HINCKLEY NATIONAL RAIL FREIGHT INTERCHANGE

*Relevant Representation on
behalf of Blaby District Council in
response to Tritax Symmetry
(Hinckley) Limited submission of
a Development Consent Order*

June 22, 2023

Relevant Representation Blaby District Council

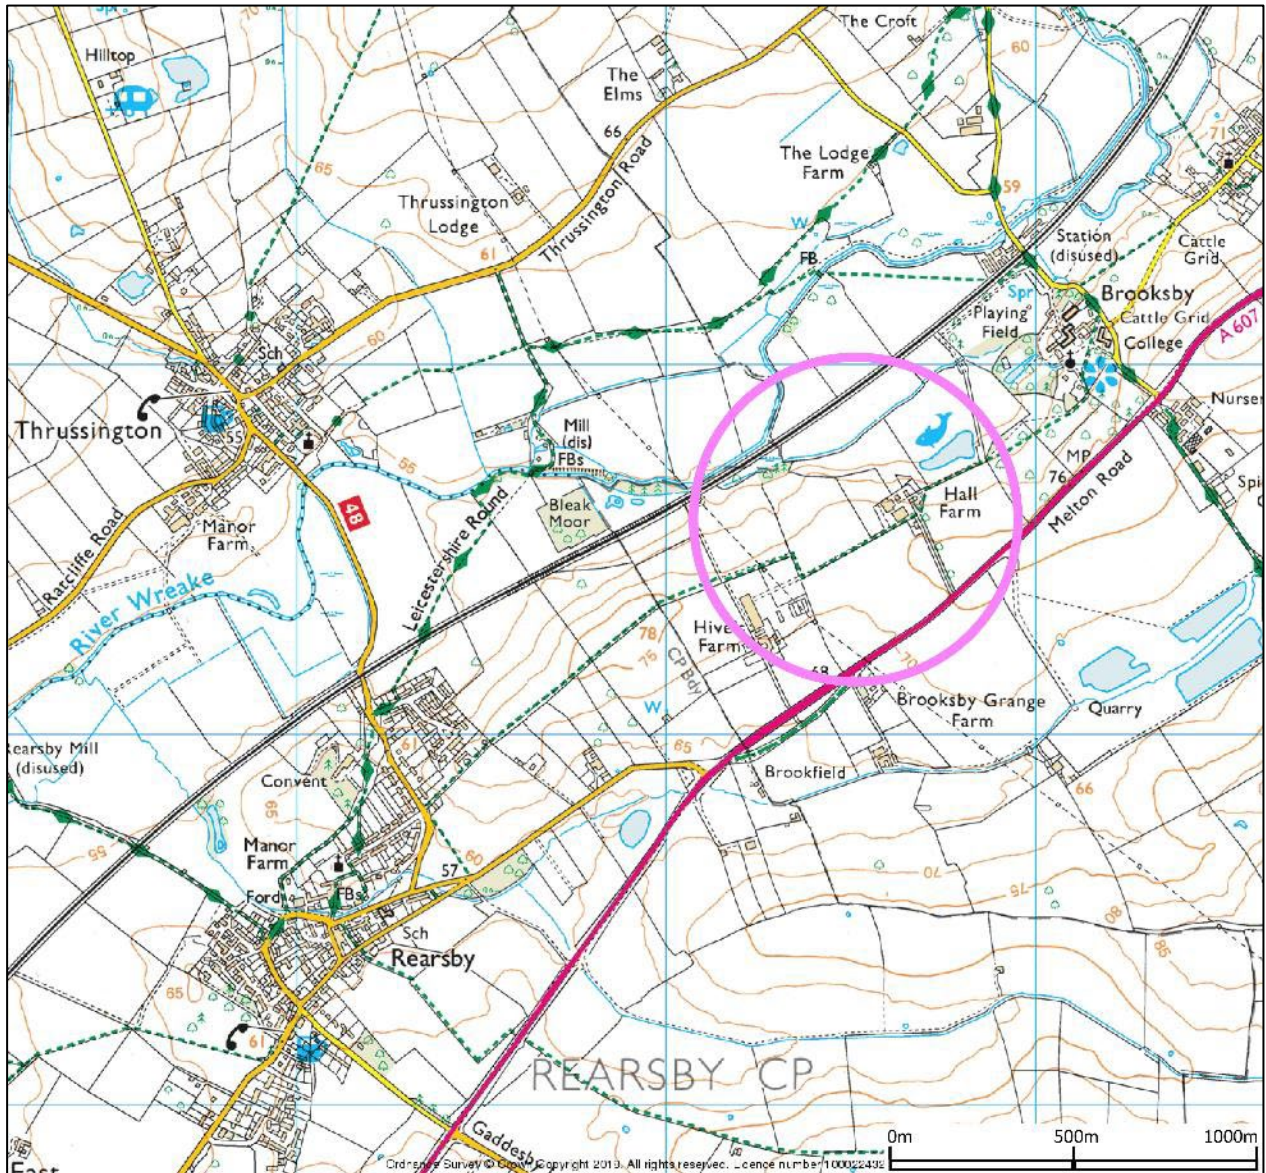
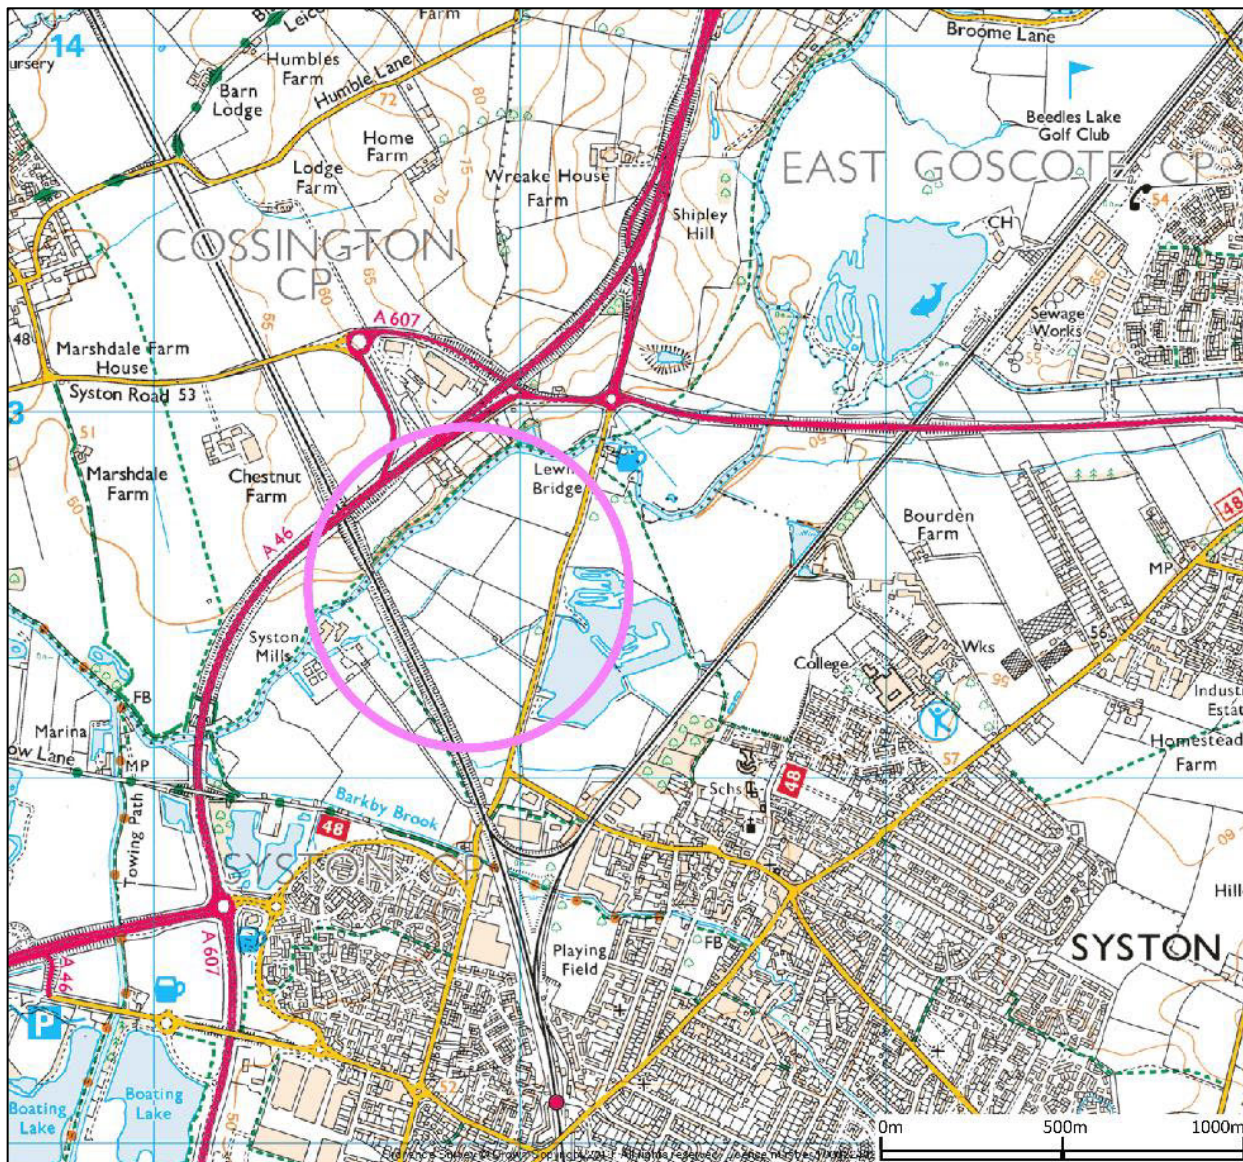
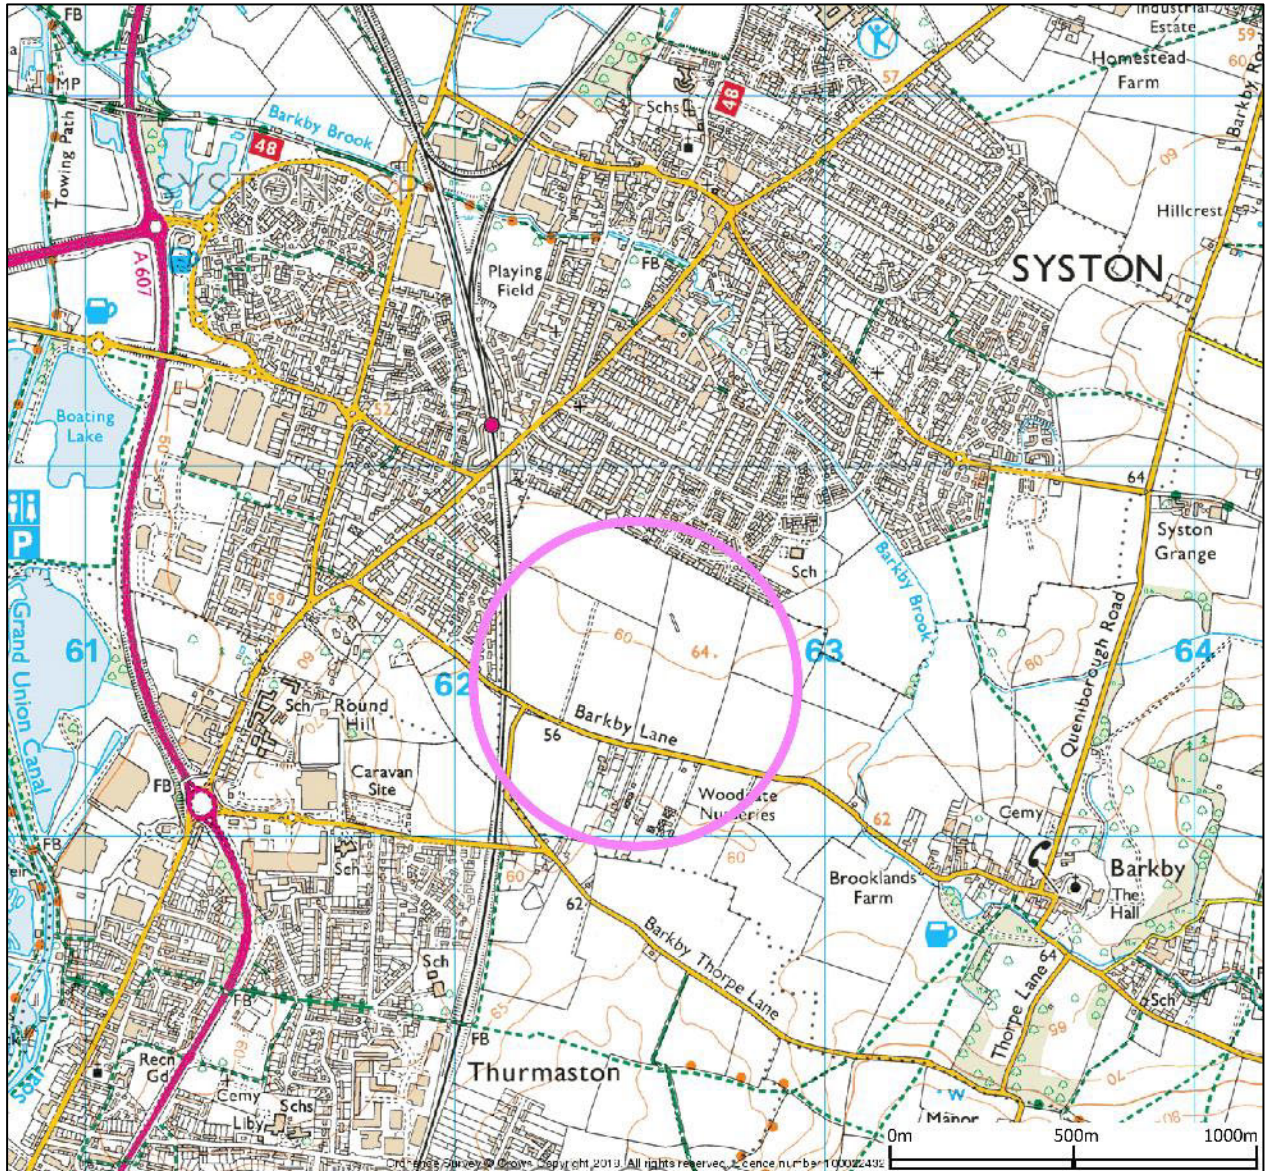
In terms of the options that were assessed, as part of the Council's Section 42 Statutory Consultation response dated 8 April 2022 ("**S42 Response**"), the Council raised concerns in respect of the relevance of site options 1 – 3 (Brooksby, Syston Fosse Way Junction and Syston Barkby Lane). Whilst the options are all to the north of Leicester and do not accord locationally with the Leicester and Leicestershire Enterprise Partnership's Strategic Economic Plan 2014-20 (March 2014), or the options also do not correlate with the more recent Leicester and Leicestershire Authorities Warehousing and Logistics in Leicester and Leicestershire: Managing growth and change (amended March 2022), it does not mean that such sites should not be considered. Moreover, additional comment was provided in respect of the potential ability to locate facilities on land to the north of Stoney Stanton or between Hinckley and Nuneaton to the south of the A5. Other than a dismissive comment on alternative sites, no enhancement of the original site assessment appears to have been undertaken. The assessment provided is therefore still considered inadequate by the Council.

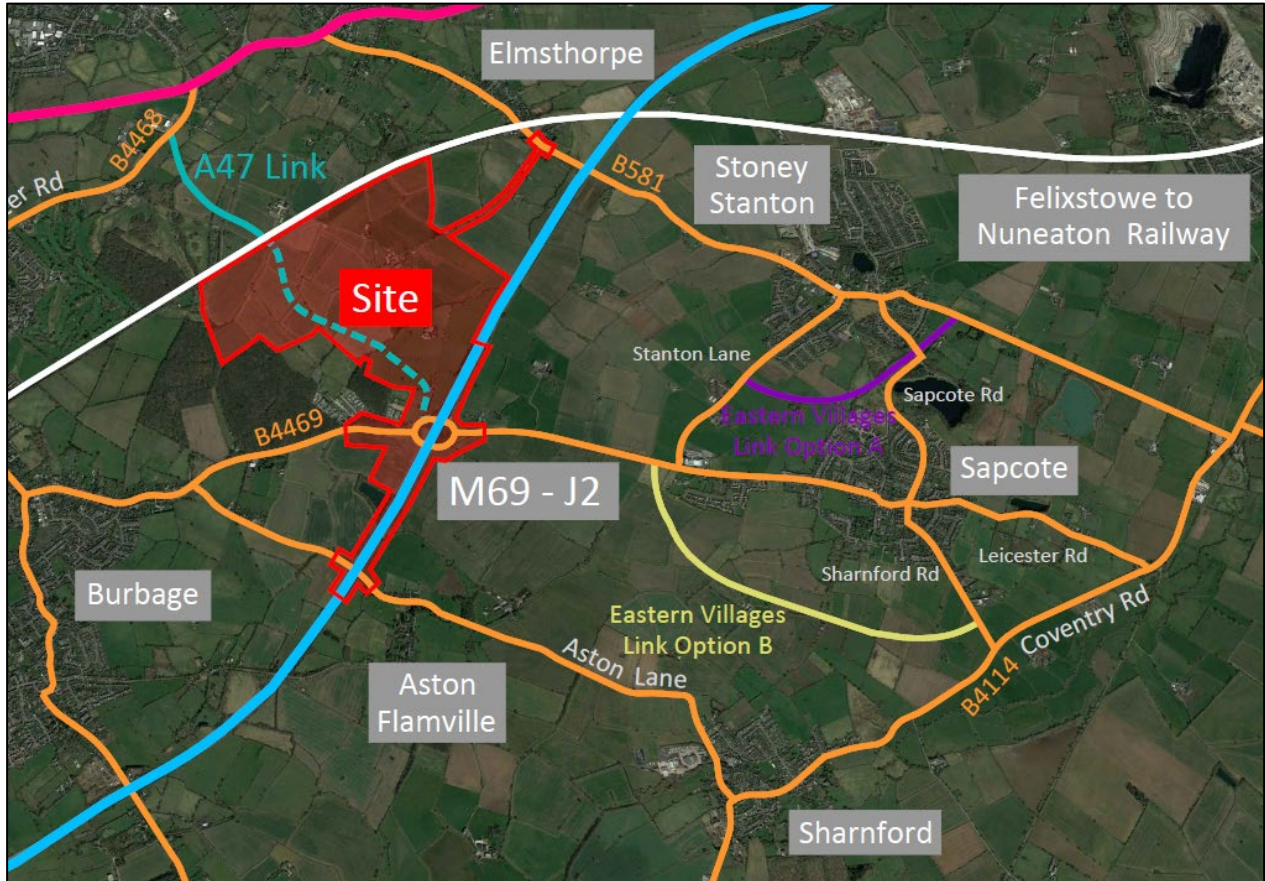
The Council's S42 Response raised concerns in respect of the layout of the Site, with any tugmaster movements needing to cross the A47 link road (see Table 4.2 of document 6.1.4 – Chapter 4 of the Environmental Statement – Site Selection and Evolution). This issue is considered important to ensure that the Scheme operates principally as a rail linked facility and not a road served distribution centre. The updated illustrative masterplan includes a 'railport estate road link' which seeks to address this previous concern. The delivery of these links needs to be clearly referenced in the 'Requirements' section of the DCO.
